DECISION DELEGATED TO DEVELOPMENT MANAGER

Application No: H19-0362-20 **Applicant:** Mr M Baker
Proposal: New Vehicular Access (retrospective)
Location: The Firs Coronation Avenue Throckenholt
Terminal Date: 26th September 2020

New access

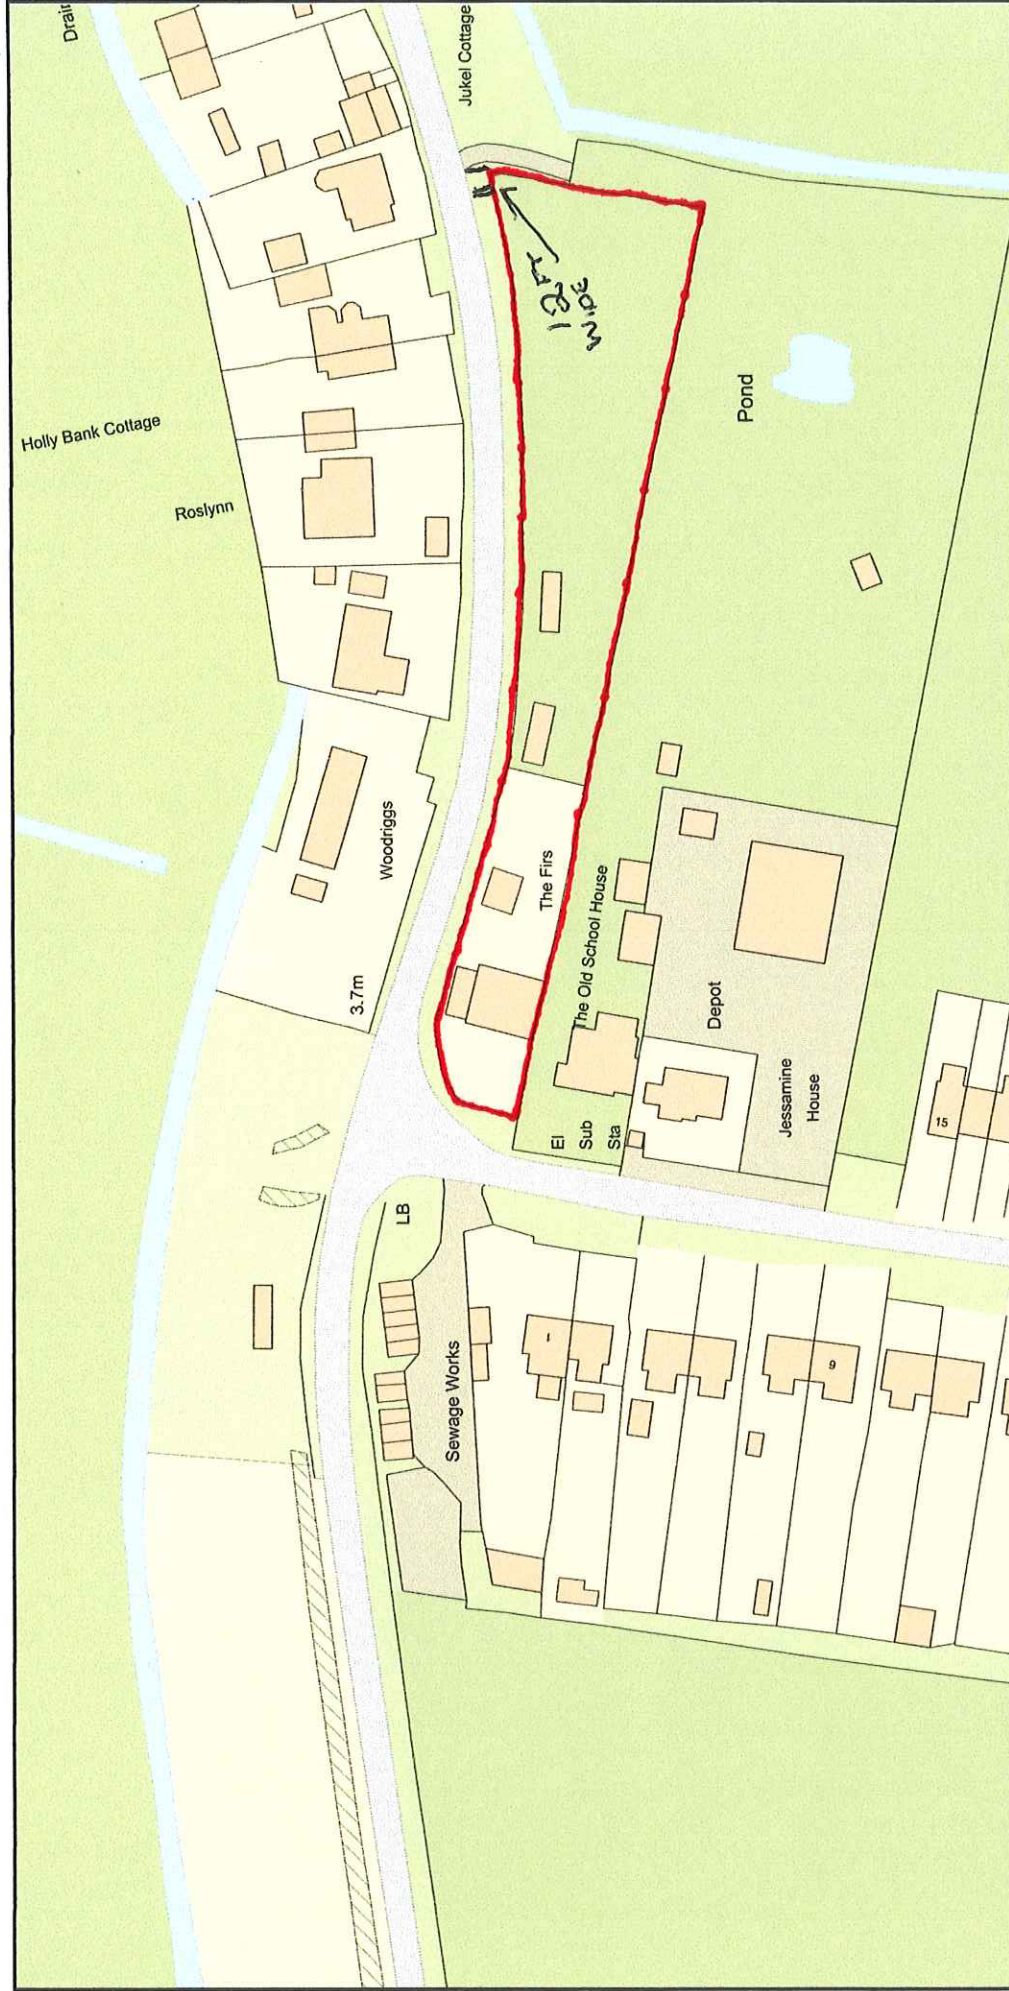
The new vehicular access is in South East Bank and adjoins one further site access that serves a different site. A timber fence delimits both accesses. There is a significant difference in site levels between the site and the highway. Both access are on a slope.

The surface on the application's vehicular access has rubble. A dense hedge of trees and shrubs is on the northern boundary of the site. A narrow verge is between the edge of the highway and the access.

However, it is reminded that the current hardcore access is not permitted within the public highway and the access must have a 1m buffer of bound material inside the private curtilage to prevent overspill on to the public highway.

The existing surface of the site access has rubble and soil. The Highway Authority expressed some concerns about the absence of treated surface to ensure safe vehicular traffic between the site and the highway through the access. After clarifying the occasional use of the access, the final consultation response has been no wish to restrict the permission subject to the recommendation of subsequent engagement of the applicant with them.

The current timber fence delimiting this access with the adjoining one is deemed acceptable as it

The presence of hardcore on the surface is not desirable as to considerations of design, layout and visual amenity. However, such issue will be addressed in subsequent discussions with Highways Authority. Appropriate surfacing is one of their specifications to ensure development proposals are acceptable on the grounds of highway safety.
